PREAPPLICATION CONFERENCE
MEETING SUMMARY

Date of Pre-Application Meeting: 9/23/15 Time: 9:00am
Pre-application meetings are scheduled every Wednesday after PR Team meetings.

Project name: Currier Heights

PLD w/ 37 cottages

SHEET NUMBER
A1.0

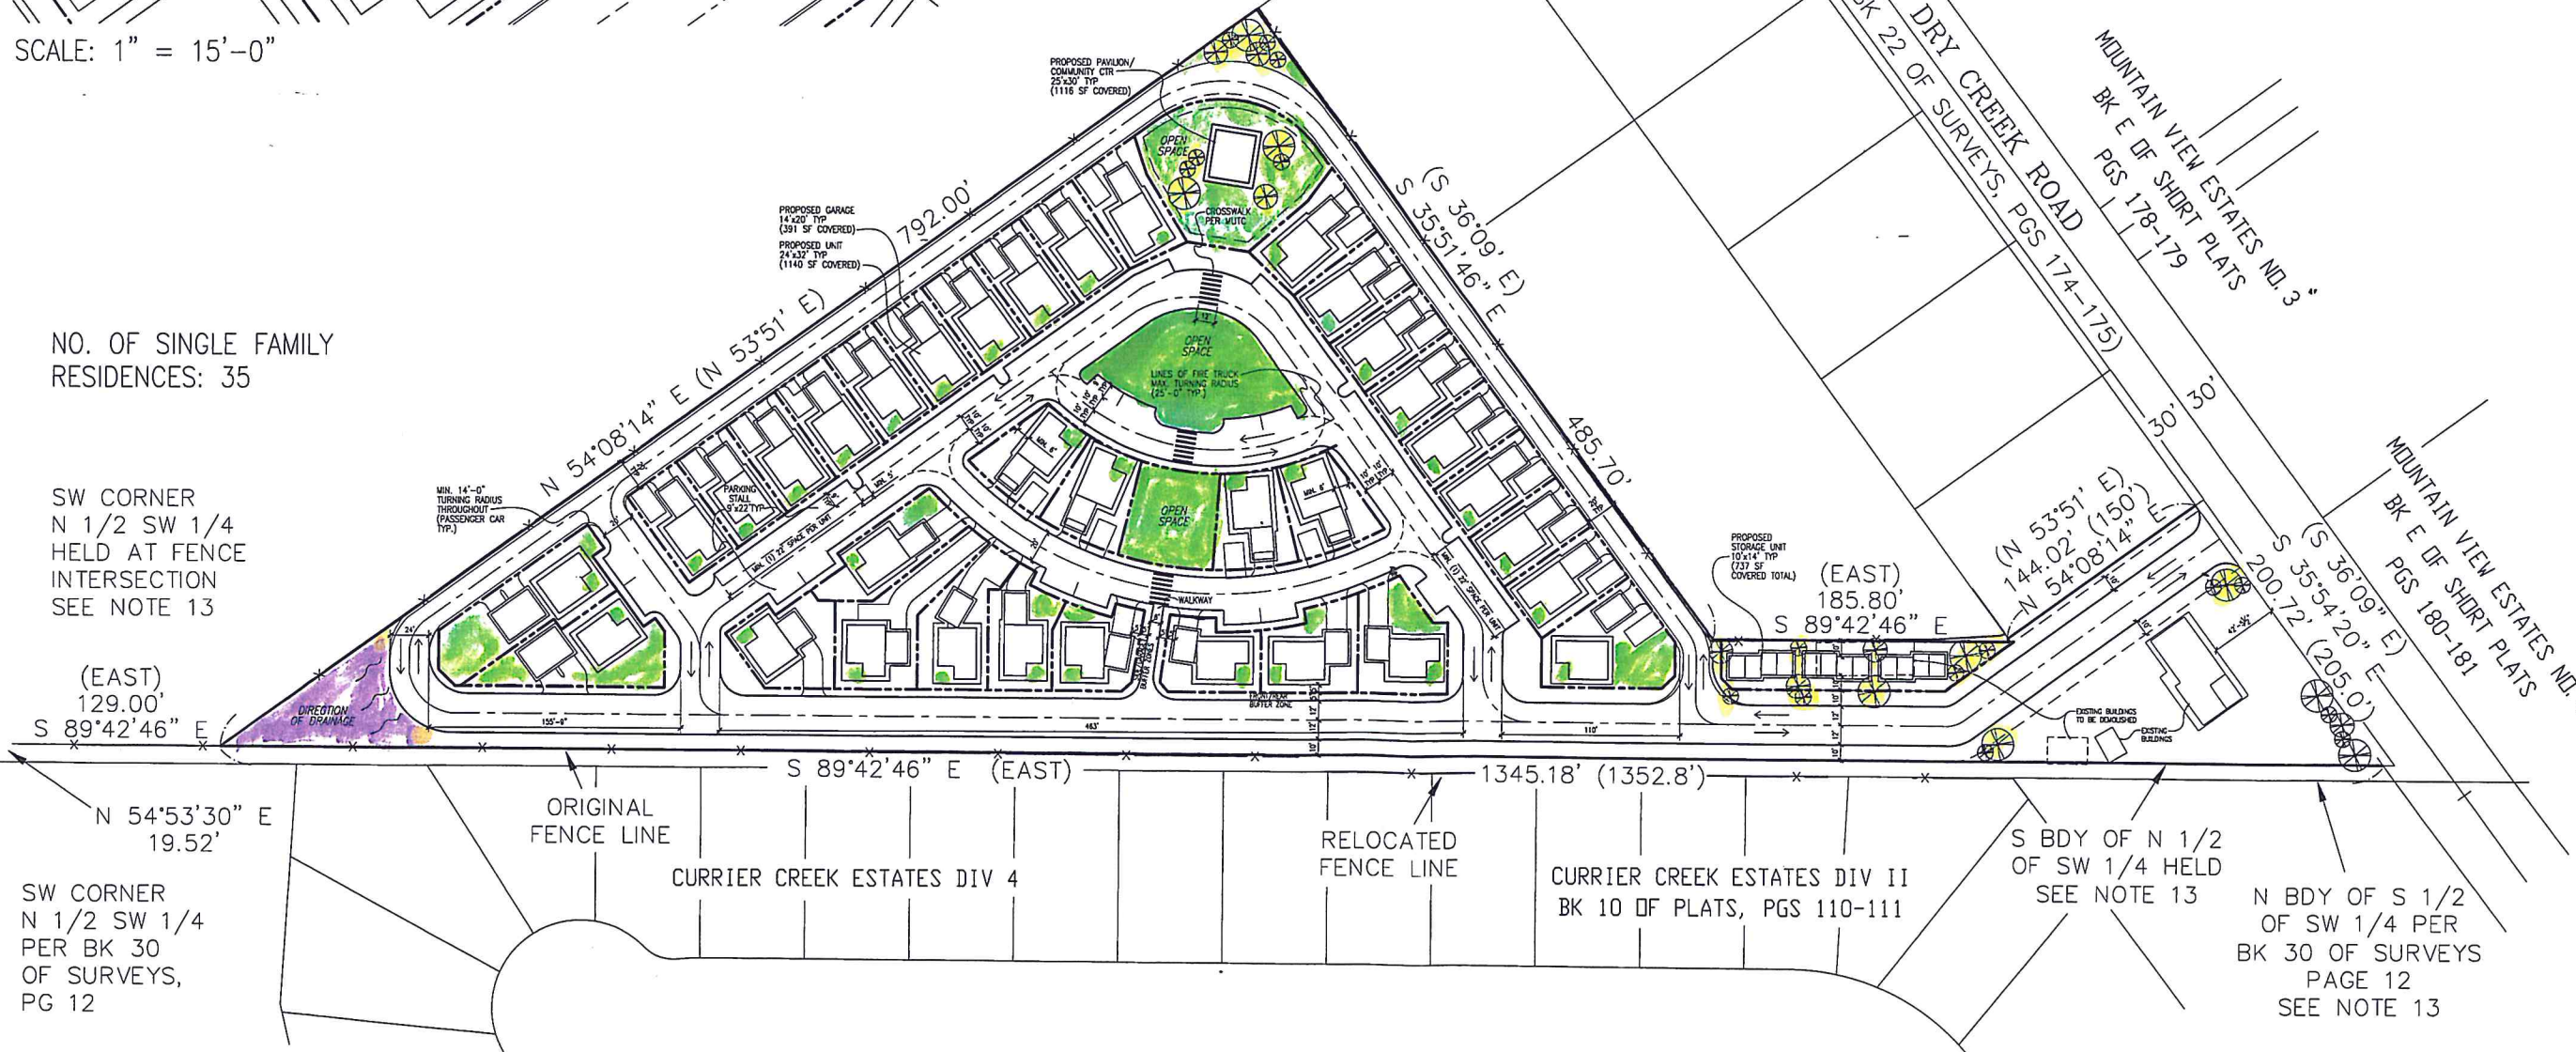
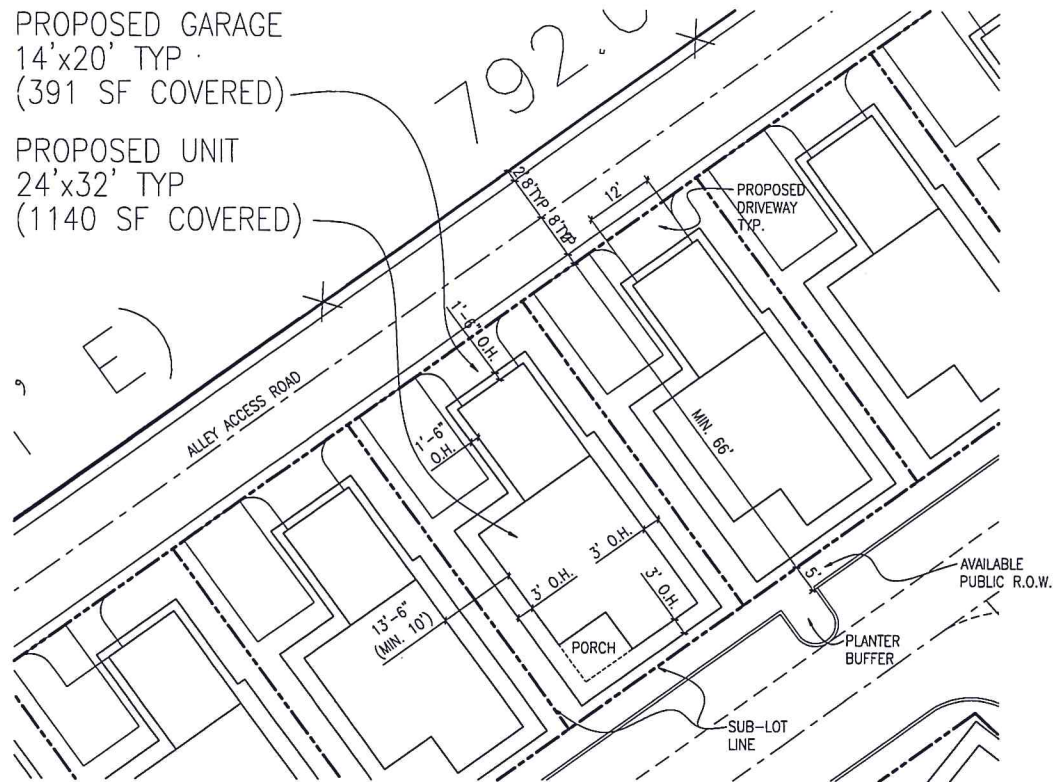
- Applicant will need to verify & work w/ property owner to the South to serve water & sewer to the PUD.
- ~~AB~~ Street will need to be built to City standards.
- Ex. house is currently shown within proposed street ROW. This will need to be addressed by shifting ROW or house demo.
